Application Reference: 2026/0470

Site Address: 20 Blakeley Close, Athersley South, Barnsley, S71 1XN

This application seeks full planning permission for the erection of a single storey extension to the south-eastern rear elevation.

Project	Rear Extension & Alterations		
Client	Mr Brett Dunn		
Title	Elevations as Proposed		
Address	20 Blakeley Close, Athersley South, Barnsley. S71 1XN		
Drawn By	GGG		
Scale	1:100 @ A4	Date Jun 26	
Drawing No	533-04	Rev

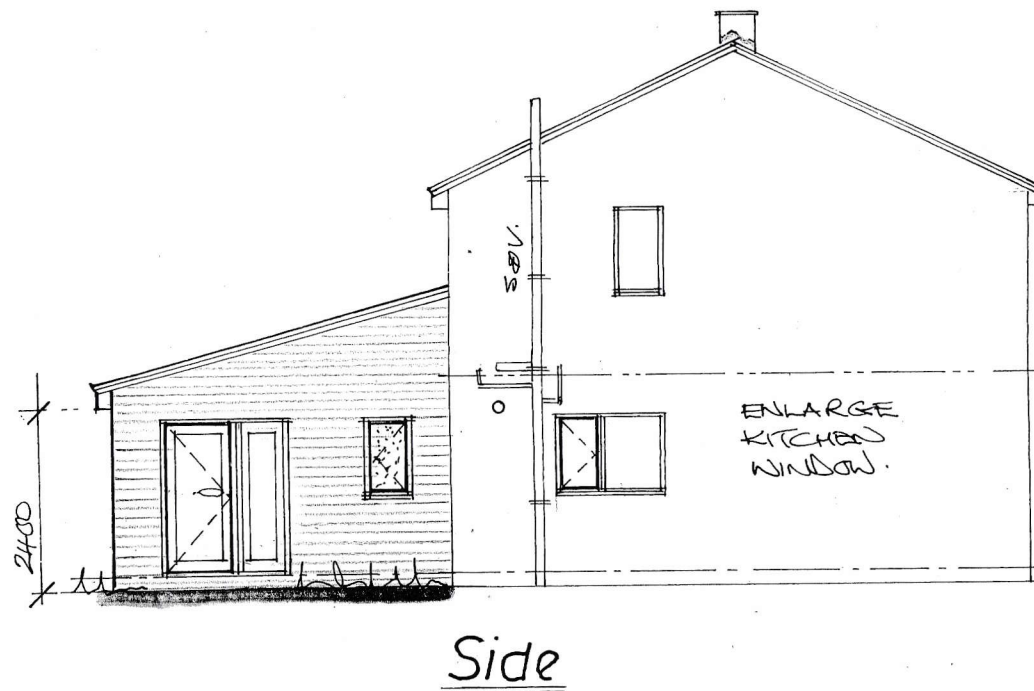
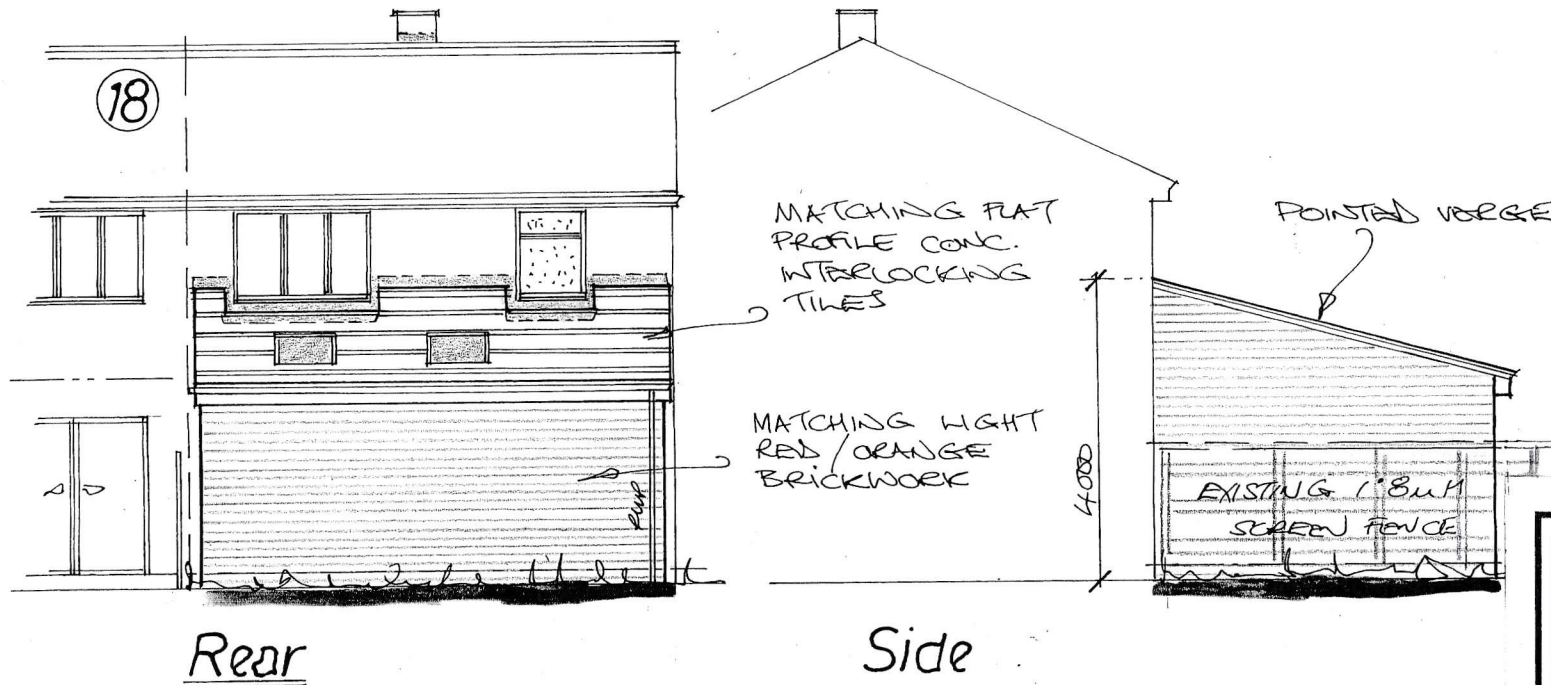
The SPD advises that single storey extension to the rear of semi-detached properties should not project more than 4m and where the extension projects beyond 3m the eaves height should not exceed 2.5m. Whilst the proposed extension would project 4.5m, the eaves height would remain below 2.5m. As such, the proposal only partially complies with this element of the SPD. However, the extension would be positioned to the north-east of the adjoining property. Given its orientation, it is not considered that the proposal would result in a significant increase in overshadowing or an unacceptable loss of natural light to neighbouring occupiers; this carries considerable weight in favour of the application.

The main impact on the neighbouring property is that of loss of outlook due to the extension's proximity to the party boundary. For the purposes of daylight and to avoid an overbearing relationship with neighbouring properties, particularly adjoining ones, a 45 degree rule is applied to assess the impact a rear extension would have. A 45 degree quadrant is taken from the mid-point of the potentially affected window; if the extension falls within this area, then it is considered that the proposal would have an overbearing impact on the neighbouring dwelling.

In this instance, the proposed extension falls within this area. As such, it does not fully accord with the principles set out in the SPD. However, the element of the extension which would have the greatest impact, could be erected under permitted development. In addition, prior notification can be sought for a larger home extension up to a projection 6m if other relevant guidelines are met. The neighbours have not objected to the proposal, and in this instance the proposed projection is considered acceptable.

It is acknowledged there are no windows proposed on the rear elevation of the extension, however, the sitting room would gain light and outlook from the windows/doors on the Southeastern elevation and additional light from the rooflight. The extension would obscure existing windows which served the kitchen/dining room but there is still an existing window serving those rooms and providing light and outlook.

The extension is somewhat unusual in that there are no windows proposed on the rear elevation resulting in a blank, brick wall. However, the extension is to be located on the rear elevation of the dwelling and would not be visible from public vantage points or be a prominent/dominant feature on the streetscene. Furthermore, the rear boundary treatments obscure views from the school beyond. As such, in this case the lack of fenestration is acceptable. This carries significant weight in favour of the application, and it is therefore considered that the proposed extension is acceptable in terms of visual amenity and in compliance with Local Plan Policy D1.

Project	Rear Extension & Alterations	
Client	Mr Brett Dunn	
Title	G. F. Layout as Proposed	
Address	20 Blakeley Close, Athersley South, Barnsley. S71 1XN	
Drawn By	GGG	
Scale	1:50 @ A3	Date Jun 26
Drawing No	533-05	Rev

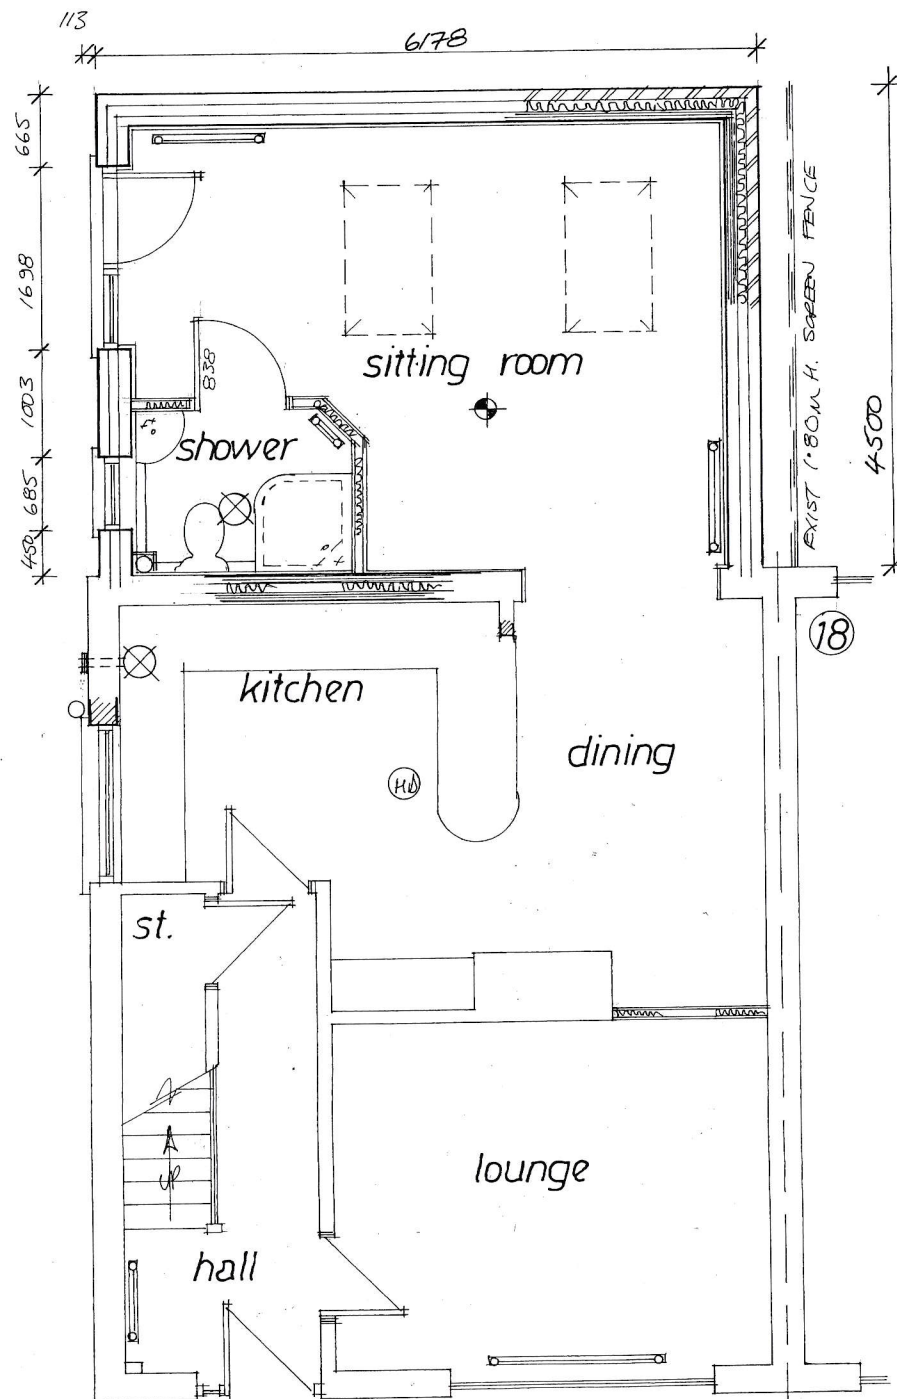
The main habitable room windows/glazed doors are to be located on the north-eastern side elevation facing into the main garden of the property and as such the proposal would not lead to an increase in overlooking; this carries considerable weight in favour of the application.
